**DEVELOPMENT FACILITATIVE TEAM (DFT)**  
**Code Enforcement Comments**

**PR-2019-002134**

**SI-2024-00716 – SITE PLAN DFT**

**REQUEST:** Site plan - administrative (DFT) for the campus of Hope Christian high school. The scope includes new facilities, renovation of existing facilities, and associated site improvements to be completed in 5 phases. Please note: this is not a site plan amendment - see justification letter included in application for explanation of current status of property regarding previously applicable master plan which expired in 2013.

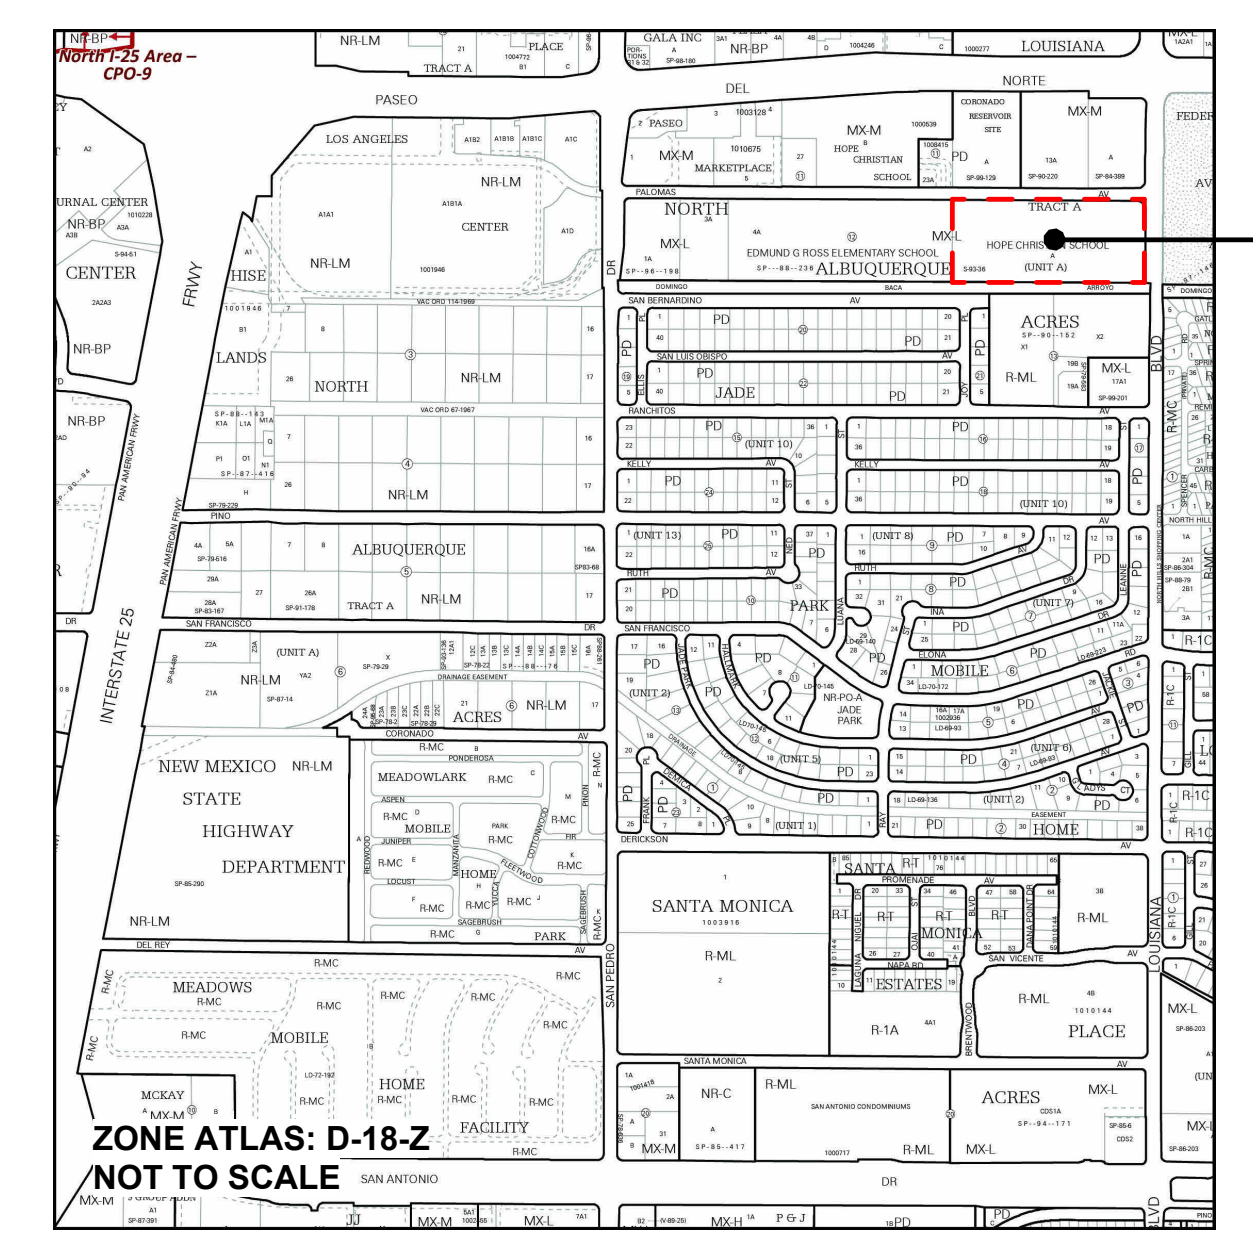
1. Property is zoned MX-L and must meet all dimensional standards of IDO T5-1(D), Table 5-1-2.
2. Parking requirements – see Table 5-5-1, and show calculations for requirements and parking provided on site plan. Proposed plans for each phase must meet all applicable parking requirements for all actual uses/activities for the lot through at that time period.

- Clarify and confirm that all development, landscaping, and screening are within private property areas and they do not encroach into the public right of way. Exception can be made for the landscape buffer along the sidewalk.

- The project & application numbers must be added to the Site Plan and any associated IL.

1. To the best of our knowledge, the proposed development meets all dimensional standards of IDO T5-1(D) & Table 5-1-2. See notes/dimensions on Site Plan sheets AS.100 & A.200.

2. To the best of our knowledge, the proposed development meets all parking requirements in Table 5-5-1. See calculation on Site Plan (AS.100).

**APPLICANT RESPONSE:** ALL DEVELOPMENT, LANDSCAPING (OTHER THAN BUFFER ALONG SIDEWALK), AND SCREENING ARE WITHIN THE BOUNDARIES OF PRIVATE PROPERTY. SEE REVISED SITE PLAN (AS.100) ATTACHED BELOW.

PROJECT NUMBER, APPLICATION NUMBER, AND IL HAVE BEEN ADDED TO REVISED SITE PLAN (AS.100) ATTACHED BELOW.

BUILDING ELEVATIONS - ALL PHASES

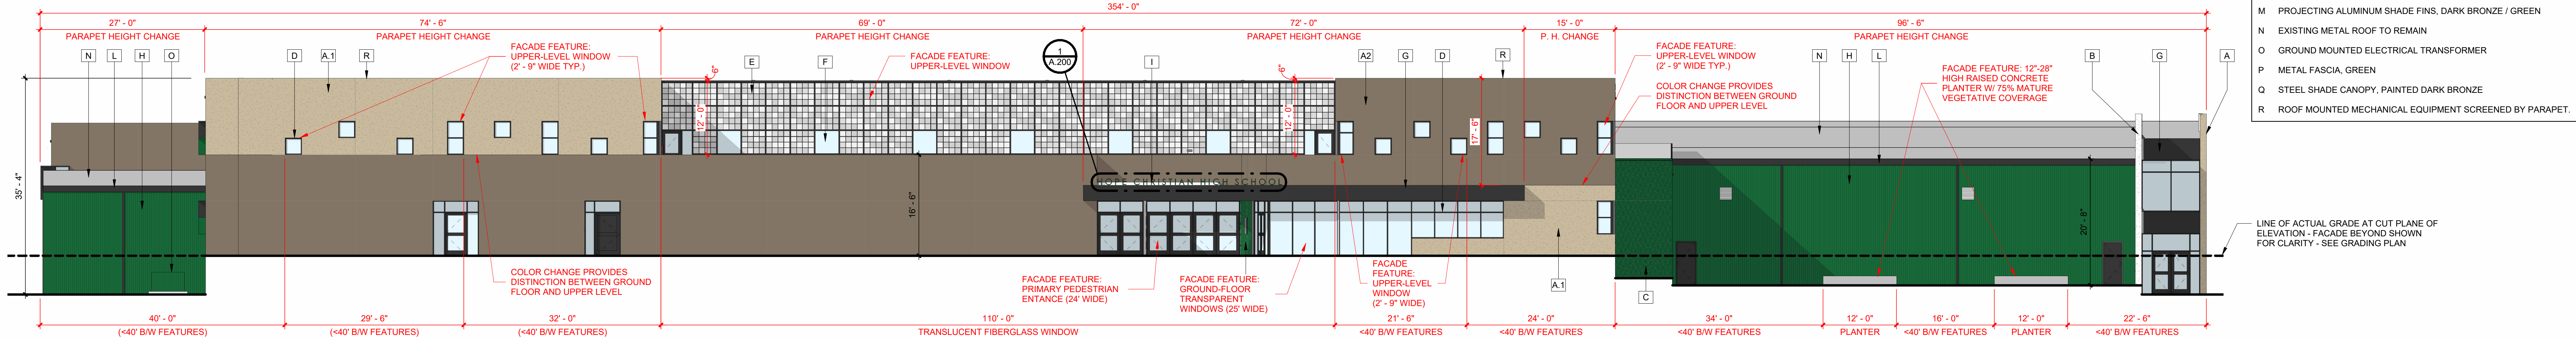
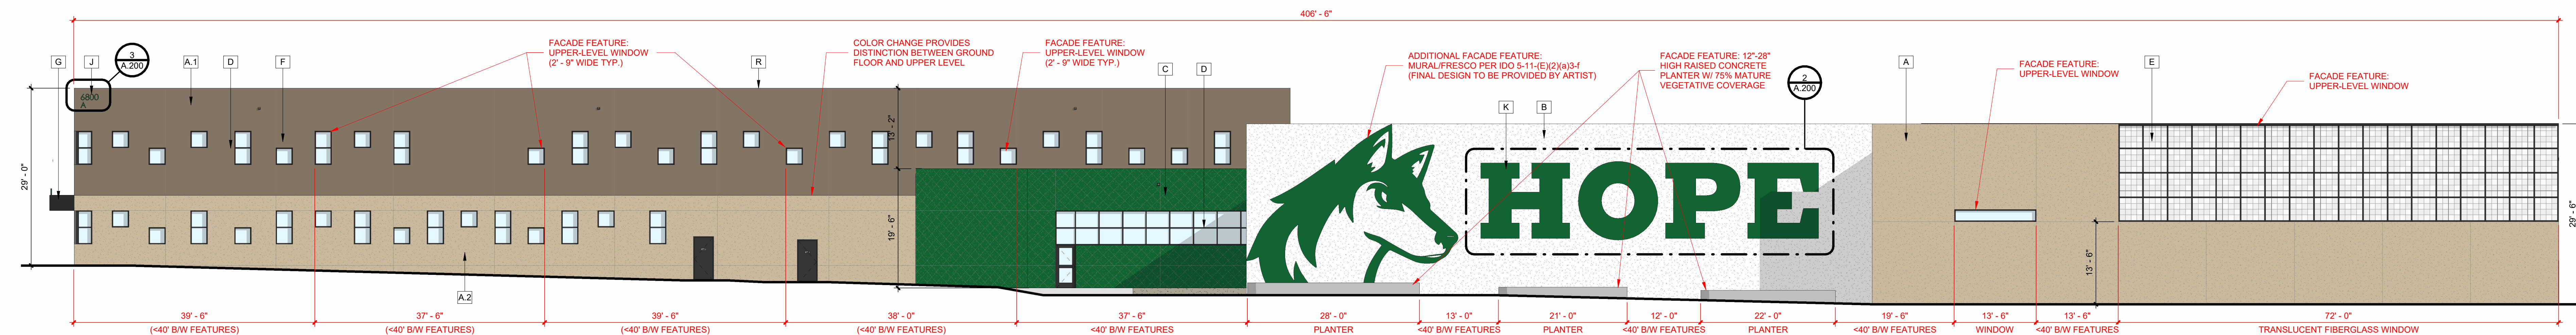
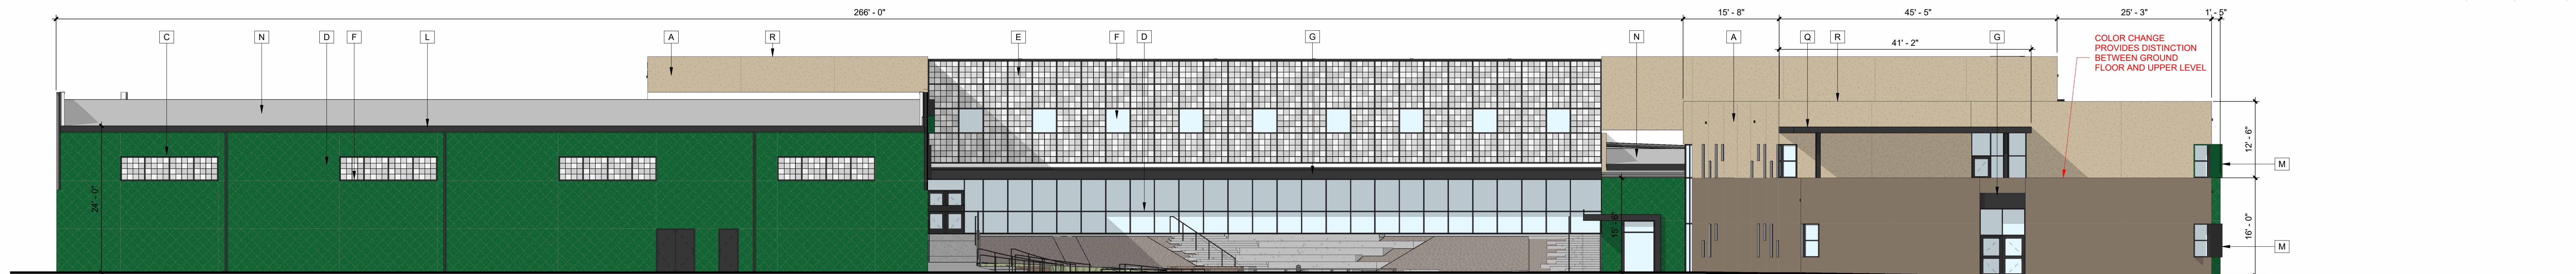
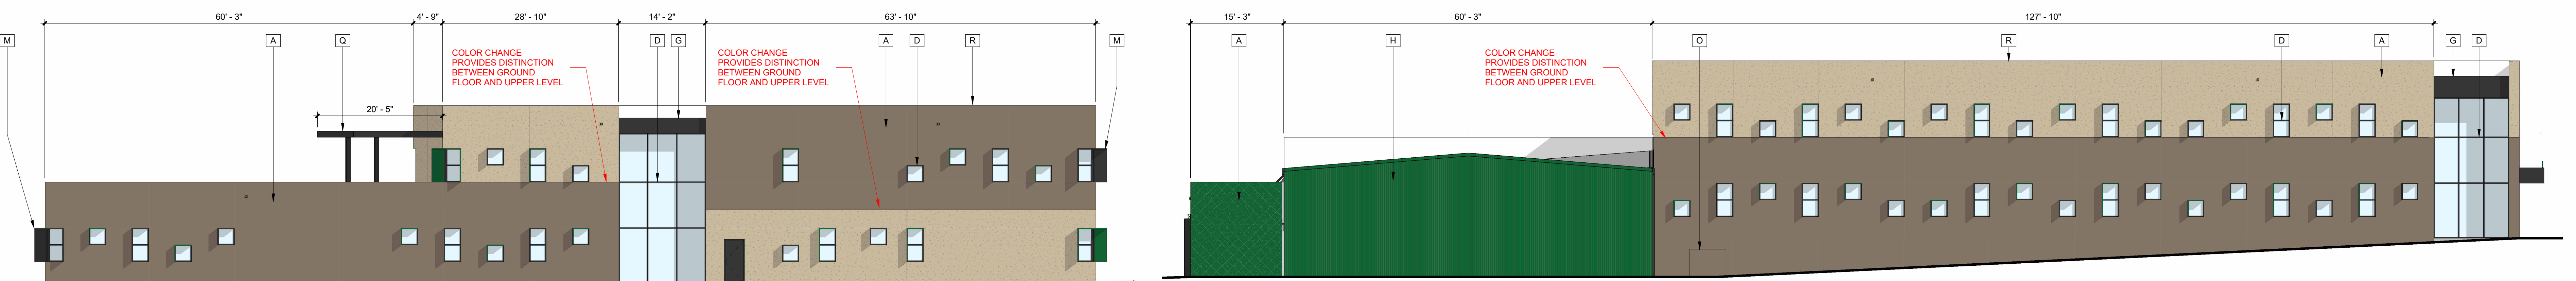
6. Signage must meet all requirements as per IDO 5-12, Table 5-12-2. Painted wall graphic with name of school would be considered a sign, and would have to be limited in size to 10% of the façade area of the wall, or a Variance obtained for the difference. Clarify calculations for area of façade being used.

- Identify how standards are being met for all parking areas. Explain calculations.  
**APPLICANT RESPONSE:** PLEASE SEE EXPLANATION/NARRATIVE ON SITE PLAN (AS.100) UNDER THE HEADING "PARKING REQUIREMENTS AND PROVISIONS".
- Identify how standards are being met for landscaping areas. Explain calculations.  
**APPLICANT RESPONSE:** PLEASE SEE NOTATION ON SITE PLAN (LP.101) UNDER THE HEADING "CITY LANDSCAPE ORDINANCE COMPLIANCE".
- Identify how standards are being met for Façade design. Explain elevations.  
Demonstrate and explain compliance with all relevant sections within 5-11-E and 5-11-E-2.

**6. Please see below attached SIGN AREA DIAGRAM** clarifying sign area calculation for facade facing Palomas Ave NE and compliance per IDO 5-12, Table 5-12-2.

**APPLICANT RESPONSE:** PLEASE SEE BELOW ATTACHED FACADE DESIGN MEMORANDUM DESCRIBING PROPOSED METHODS OF COMPLIANCE WITH IDO 5-11-E AND 5-11E-2

- Primary pedestrian entrance (5-11(E)(2)(a)-2-c)
    - Raised planters (5-11(E)(2)(a)-2-f)
  - o The façade features described above are distributed across the street-facing façades so that at least 1 of the incorporated features occurs every 40 feet. See A.200 elevations for dimensions between features.

- Additional façade feature proposed:
        - Privately owned mural (5-11(E)(2)(a)-3-f). Final design to be provided by artist. See A.200 elevations for location.

- A change in parapet height at least every 100' of façade length (5-11(E)(2)(a)-3-e). See A.200 elevations for dimensions between parapet height changes.

1 ELECTRICAL SITE PLAN
1" = 30'-0"

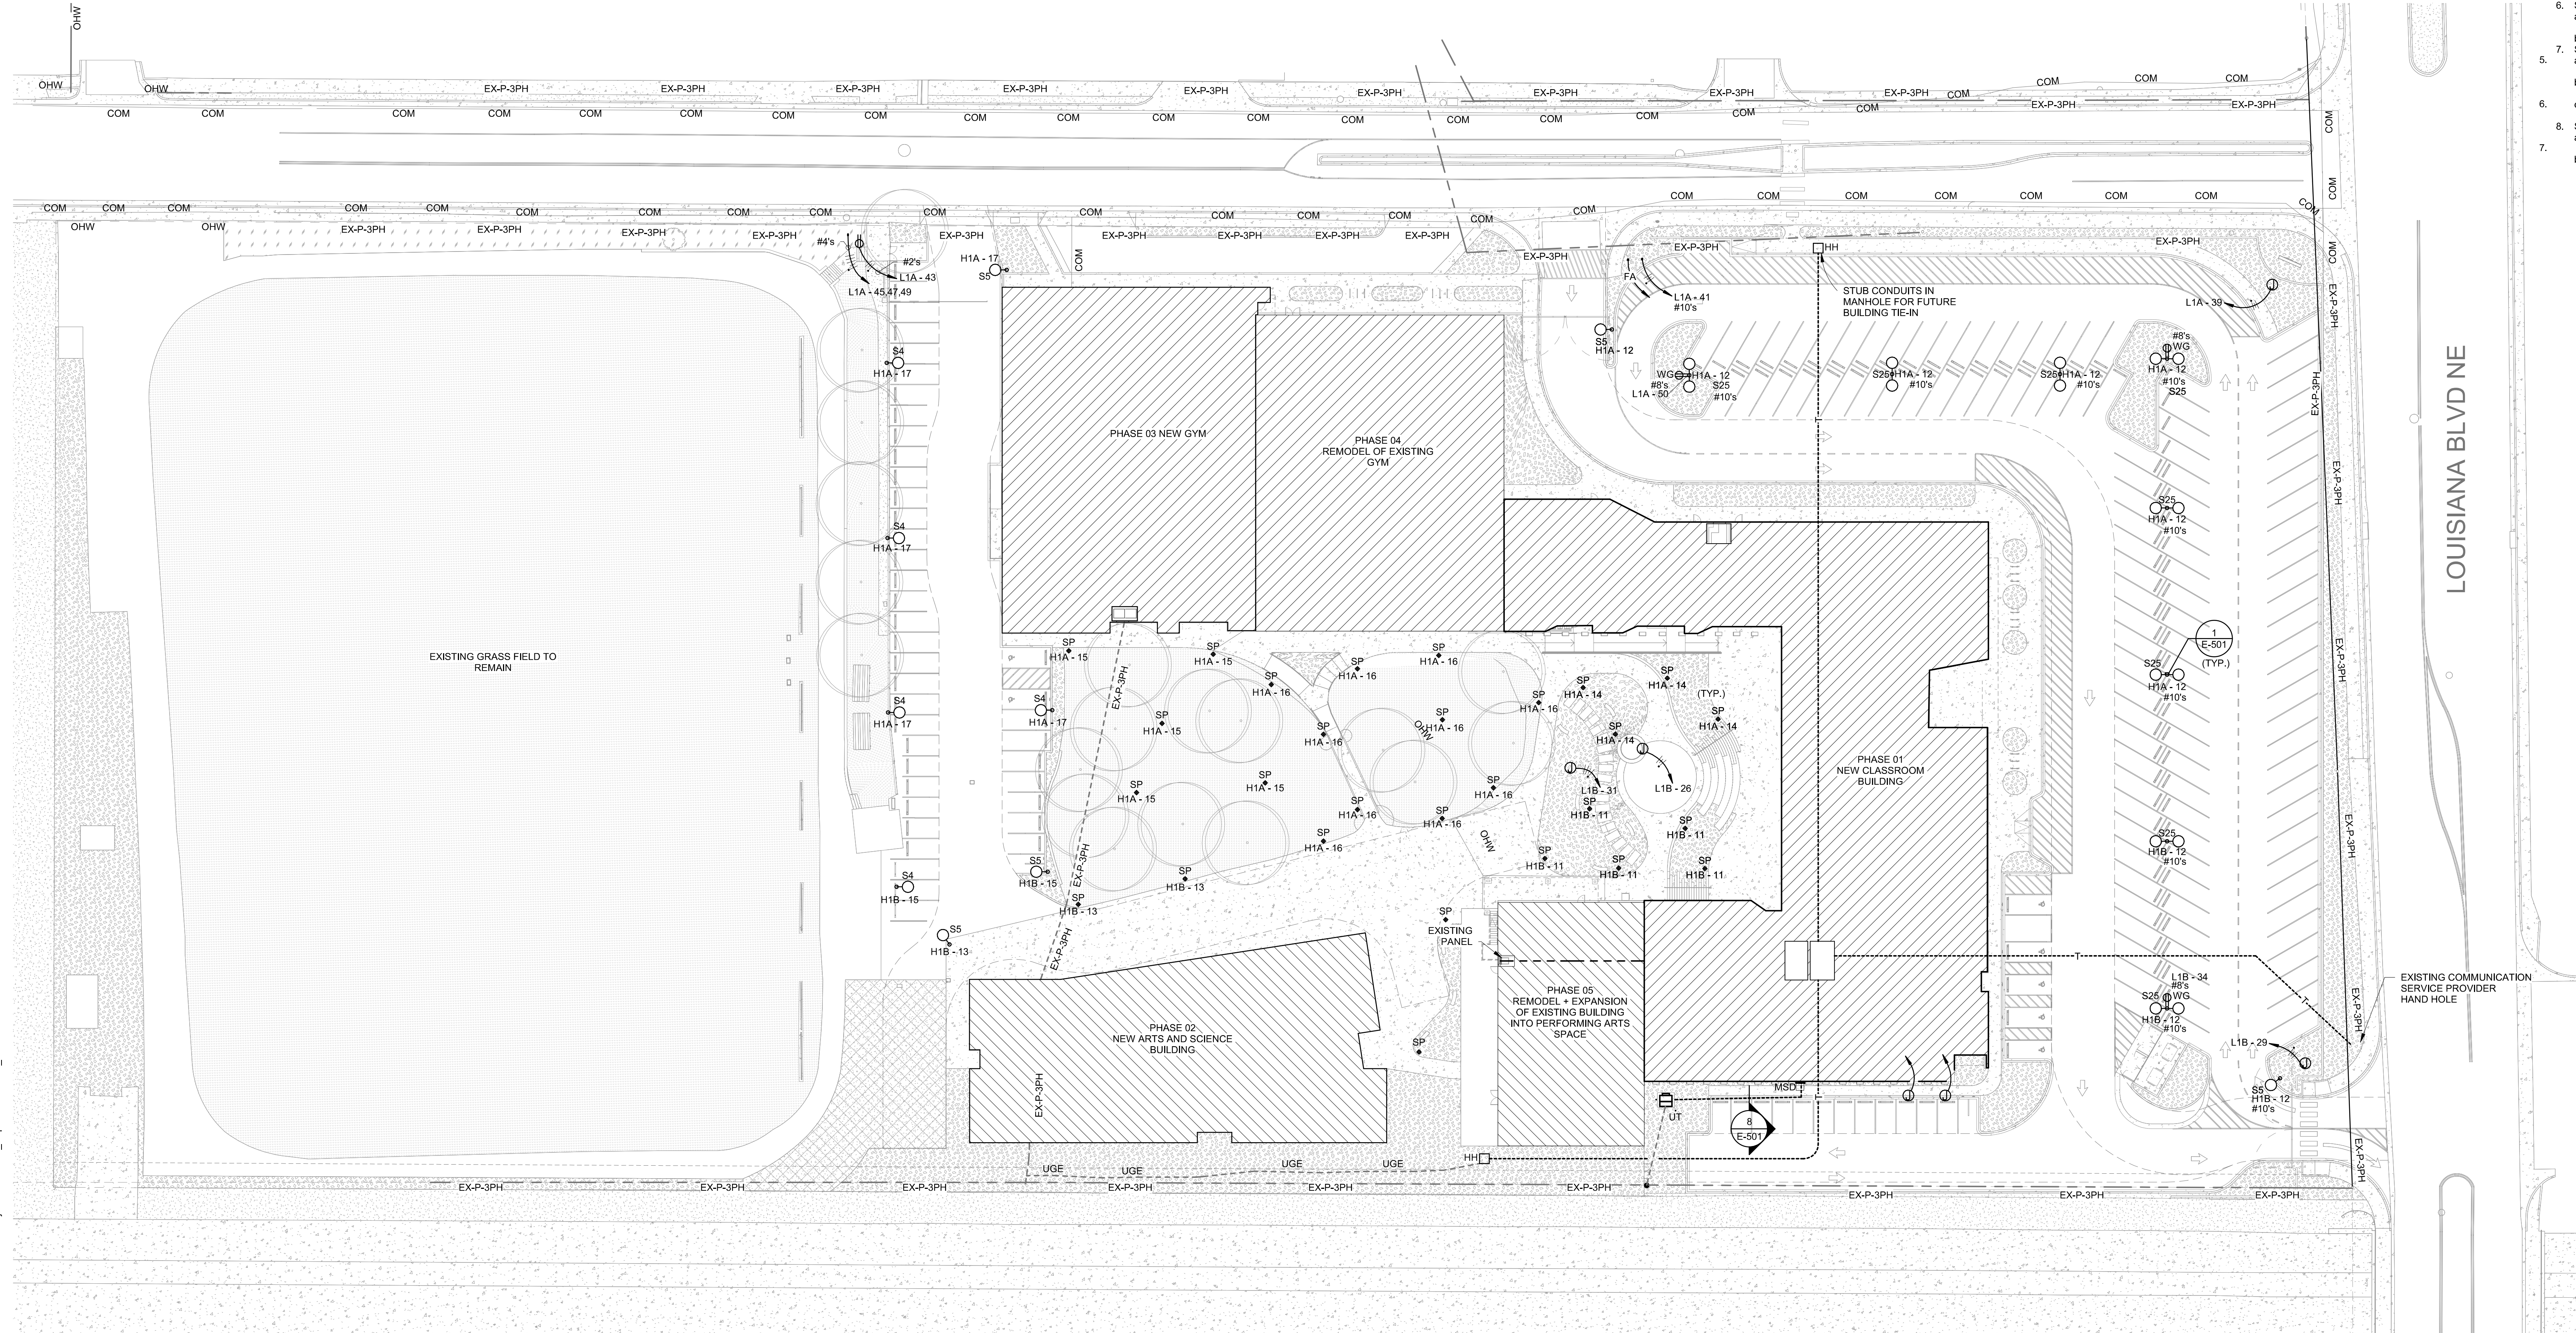
4. Landscaping: clarify when landscaping is to be installed in what phases, and how it will meet requirements before and during future phases.
5. All lighting must meet requirements of IDO 5-8 Outdoor and Site Lighting.

- Provide a lighting plan with dimensions demonstrating the it meets IDO section 5-8.

**5. Please see below attached ES.102 OVERALL ELECTRICAL SITE PLAN & ES.103 ELECTRICAL SITE PLAN CALCULATIONS** sheets addressing the requirements of IDO 5-8.

SEE ABOVE ATTACHED LIGHTING PLAN DEMONSTRATING COMPLIANCE WITH IDO 5-8
